# CITY OF ALBUQUERQUE

**Re: Via Electric, 2211 Candelaria NE.**  
**Grading and Drainage Plan**  
**Engineer's Stamp dated 11-01-13 (H16/D087)**

Based upon the information provided in your submittal dated 11-08-13, the above referenced plan cannot be approved for building permit until the following comments are addressed.

SHEET NUMBER
C-2

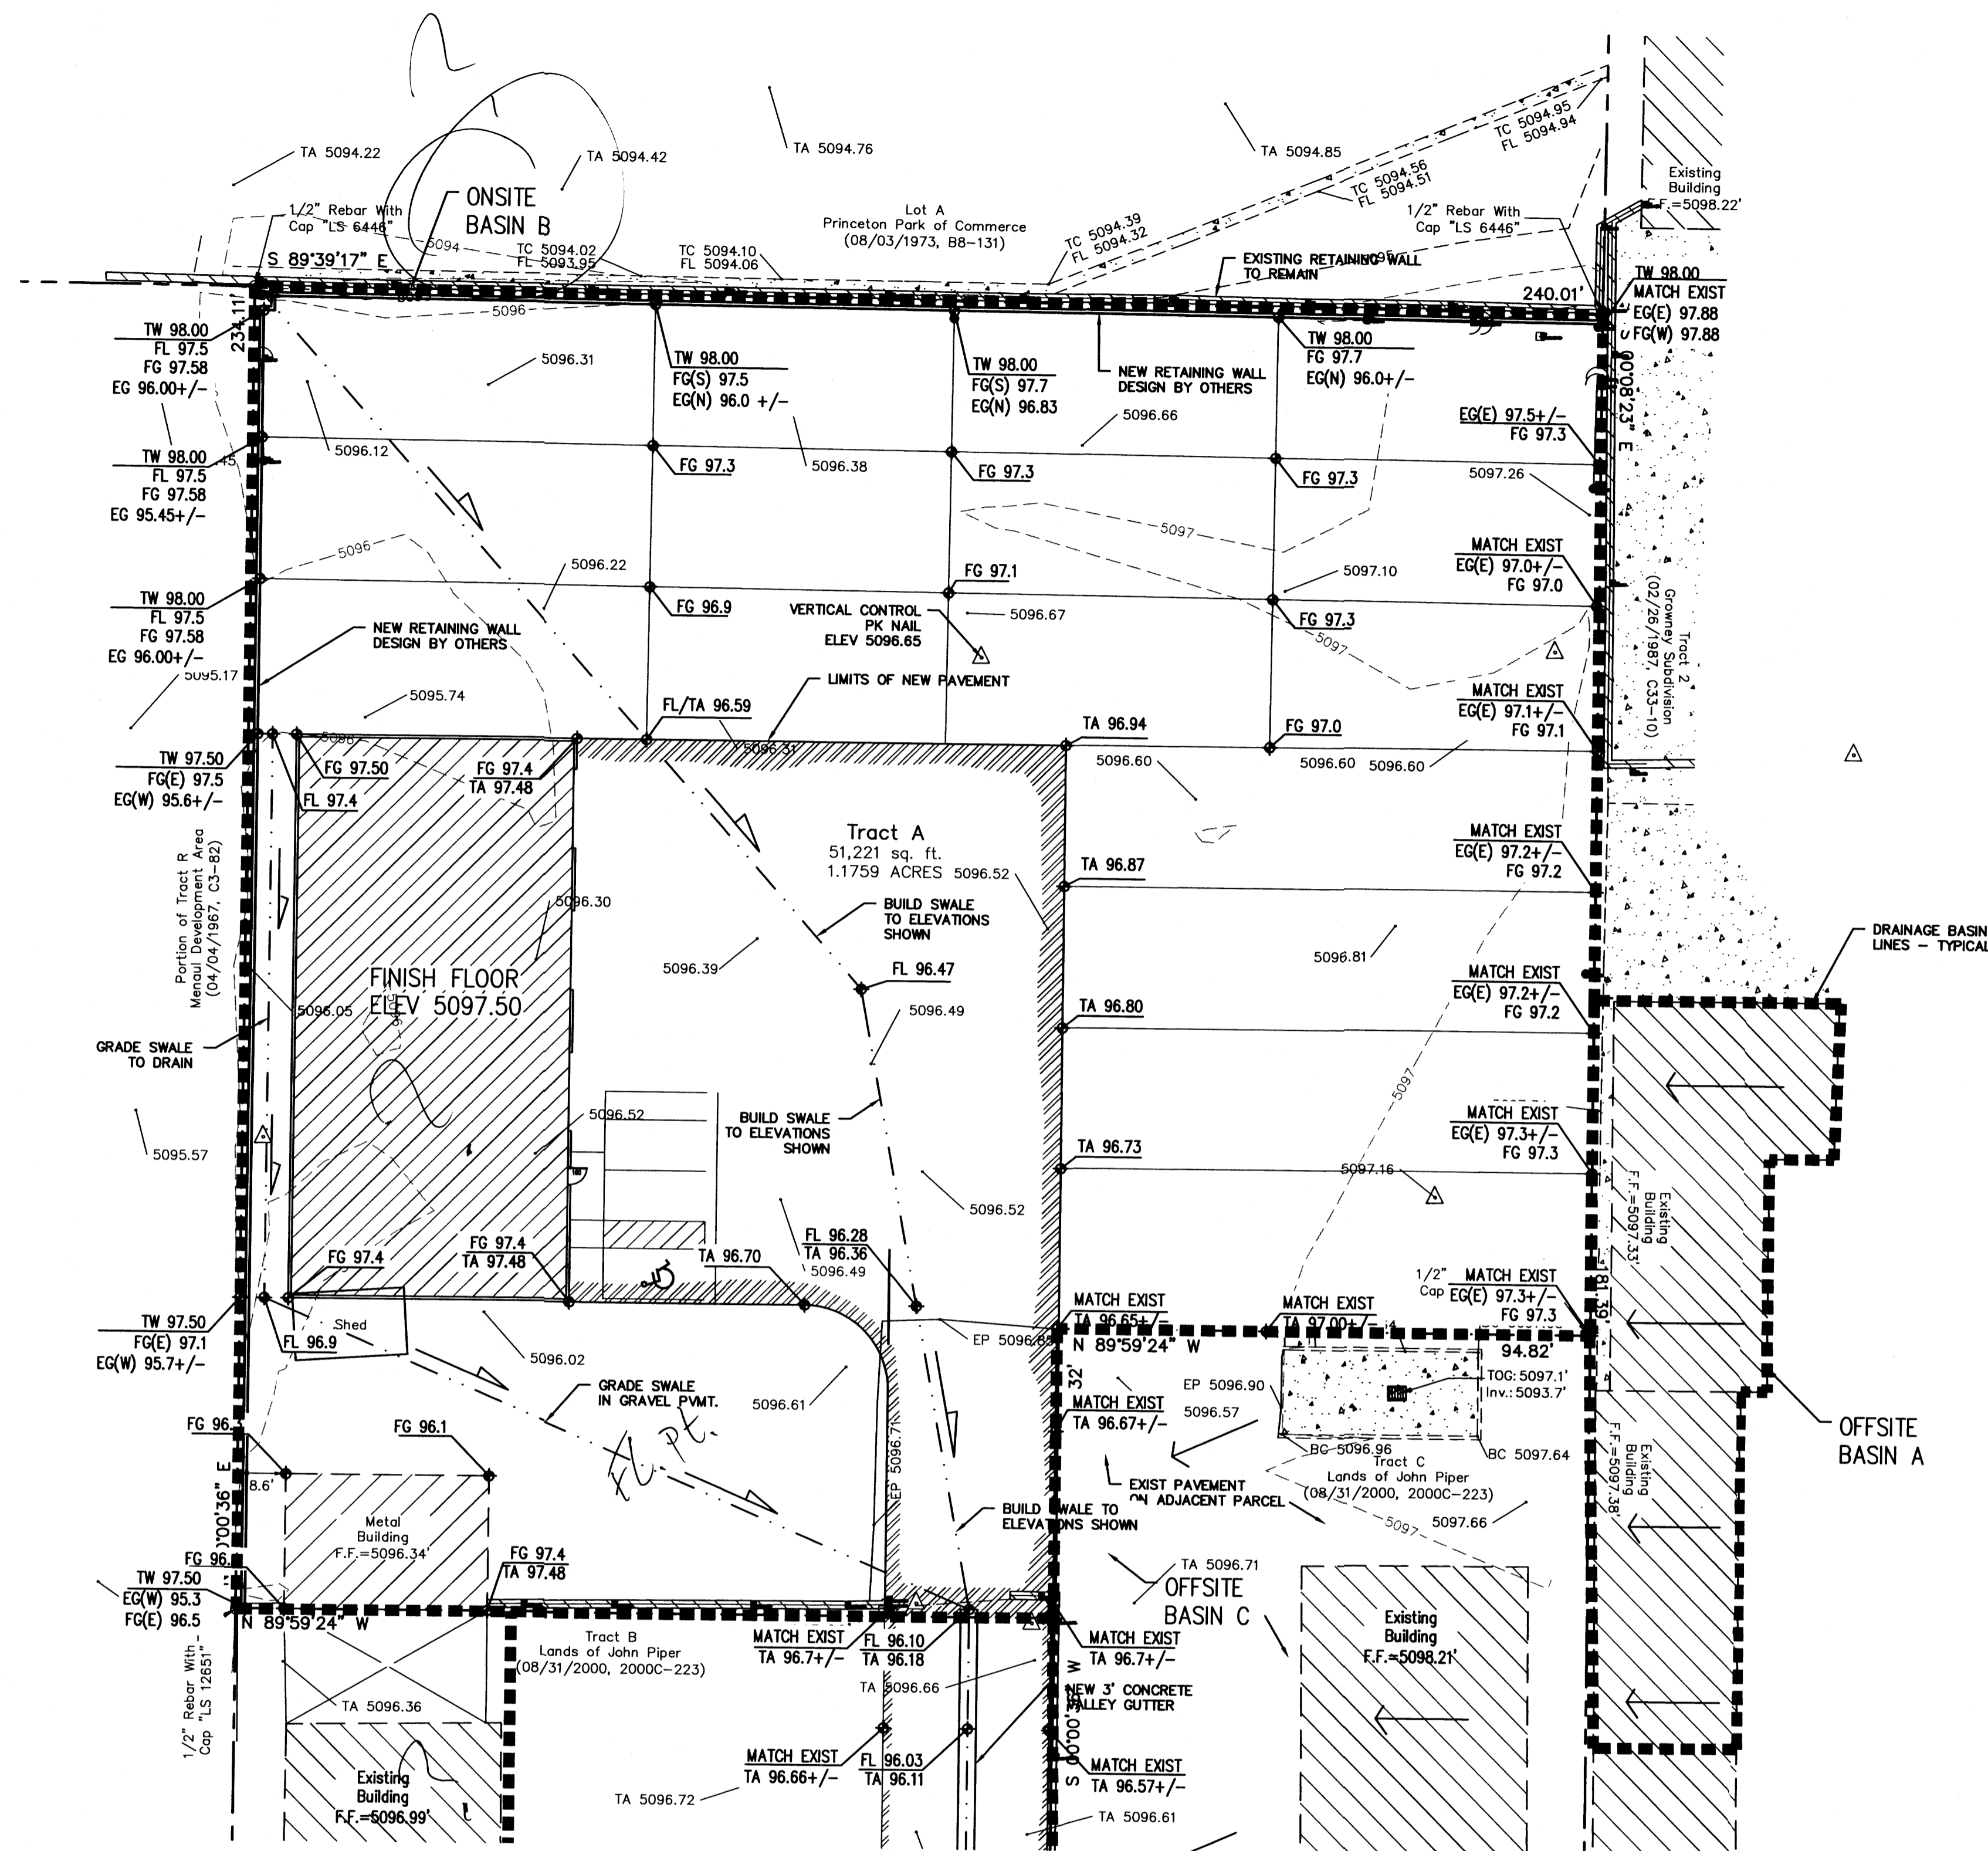
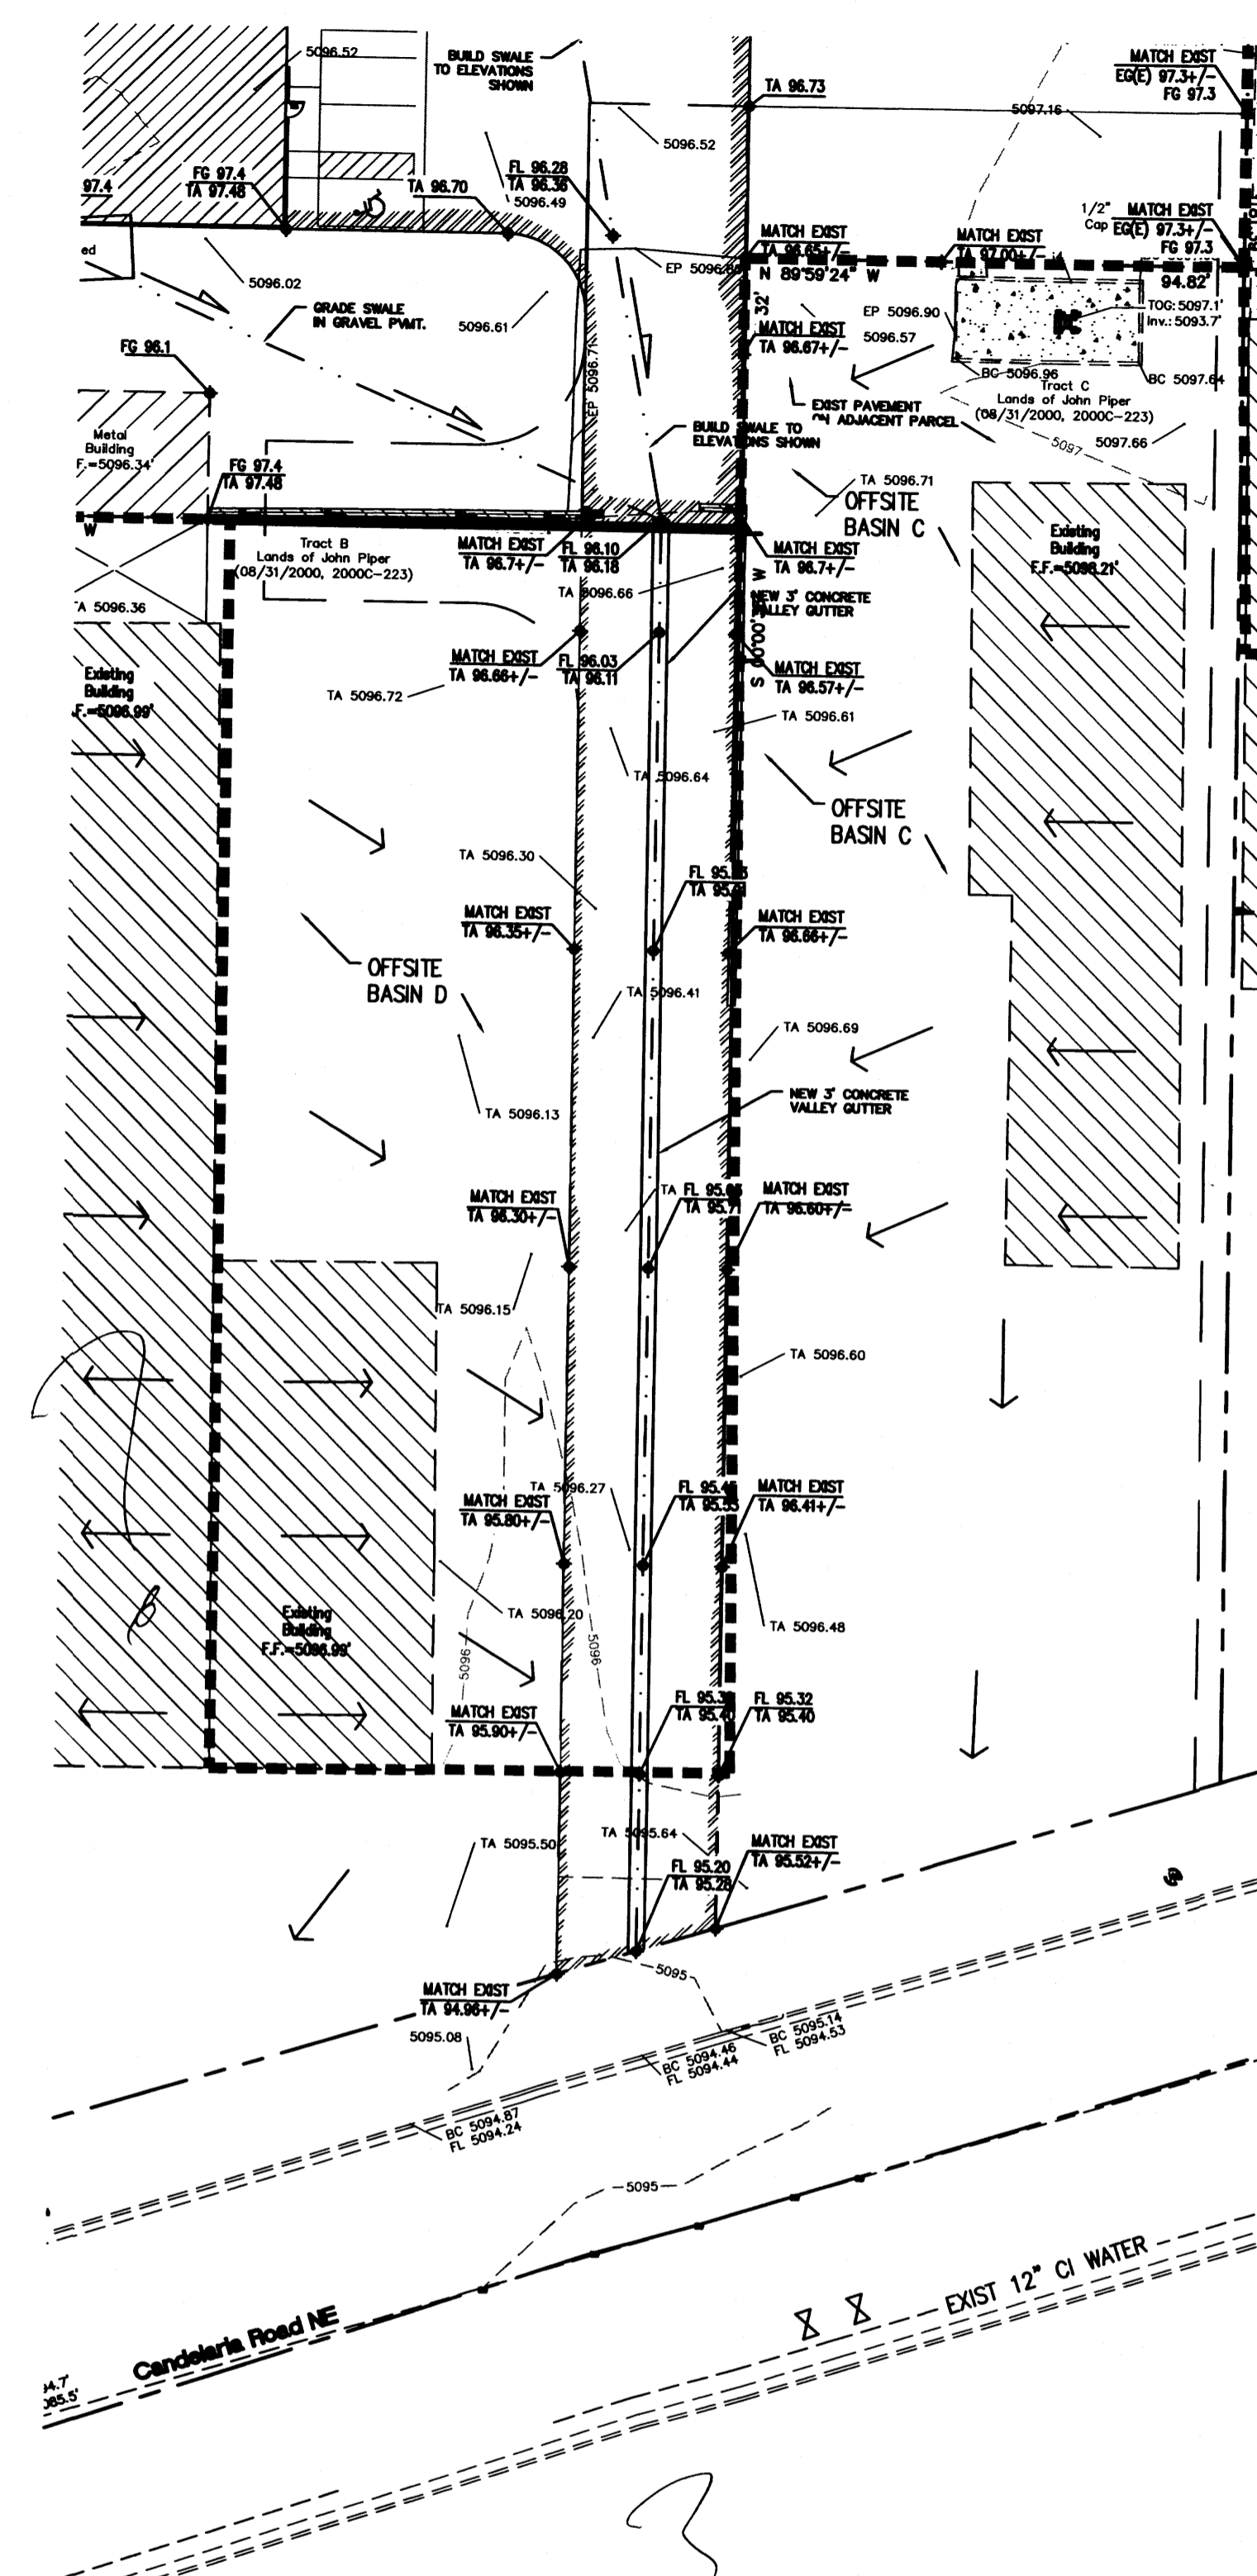
- A cross lot drainage agreement is needed.
- Flow points are needed for both swales.
- A basin map is required.
- Number 2 easement grading plan is not the correct scale.
